Your Ref: LU/193/12/

Our Ref: PLAN-001082

Proposal: Proposed detached garage.

Site: 75A Clun Road, Littlehampton, West Sussex BN17 7ED.

SITING AND ROOF PLAN 1 : 100

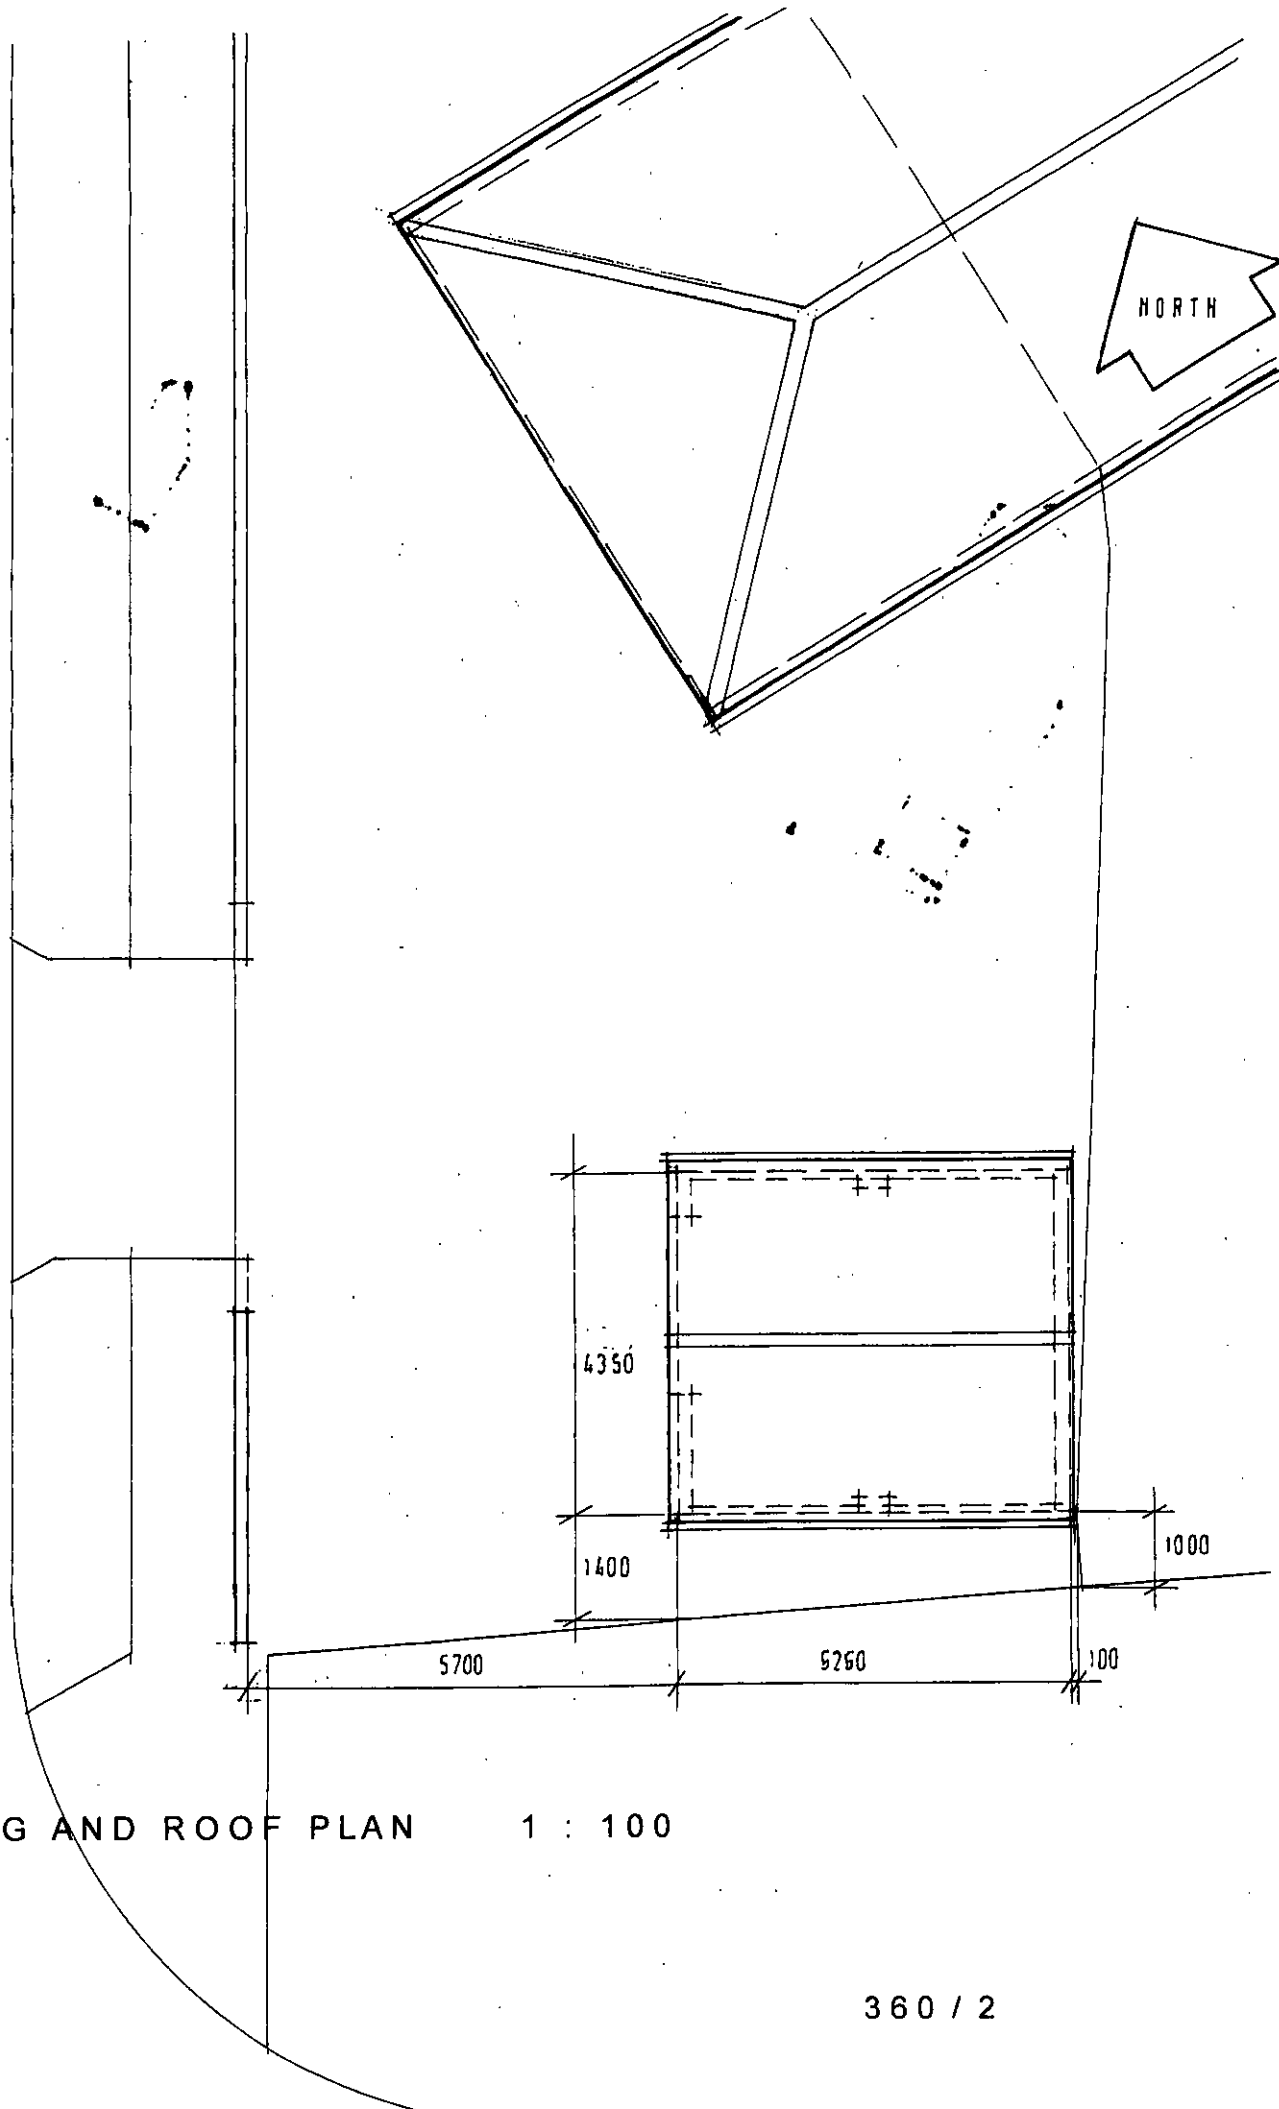
Please find attached a plan of the sewer records showing the approximate position of a public sewer crossing the site. The exact position of the public sewers must be determined on site by the applicant before the layout of the proposed development is finalised.

- 1.The 225 mm diameter sewer requires a clearance of 3 metres either side of the sewer to protect it from construction works and allow for future access for maintenance.
- 2.No development or new tree planting should be located within 3 metres either side of the centreline of the public sewer
- 3.No new soakaways should be located within 5 metres of a public sewer.
- 4.All other existing infrastructure should be protected during the course of construction

The applicant has not stated details of the proposed means of disposal of foul and surface water from the site. Alternative means of draining surface water from this development are required. This should not involve disposal to a public foul sewer.

Alternatively, the applicant may wish to amend the site layout, or combine a diversion with amendment of the site layout. If the applicant would prefer to advance these options, items (1) – (4) above also apply.

In order to protect drainage apparatus, Southern Water requests that if consent is granted, a condition is attached to the planning permission. For example "The developer must advise the local authority (in consultation with Southern Water) of the measures which will be undertaken to divert the public sewers, prior to the commencement of the development."
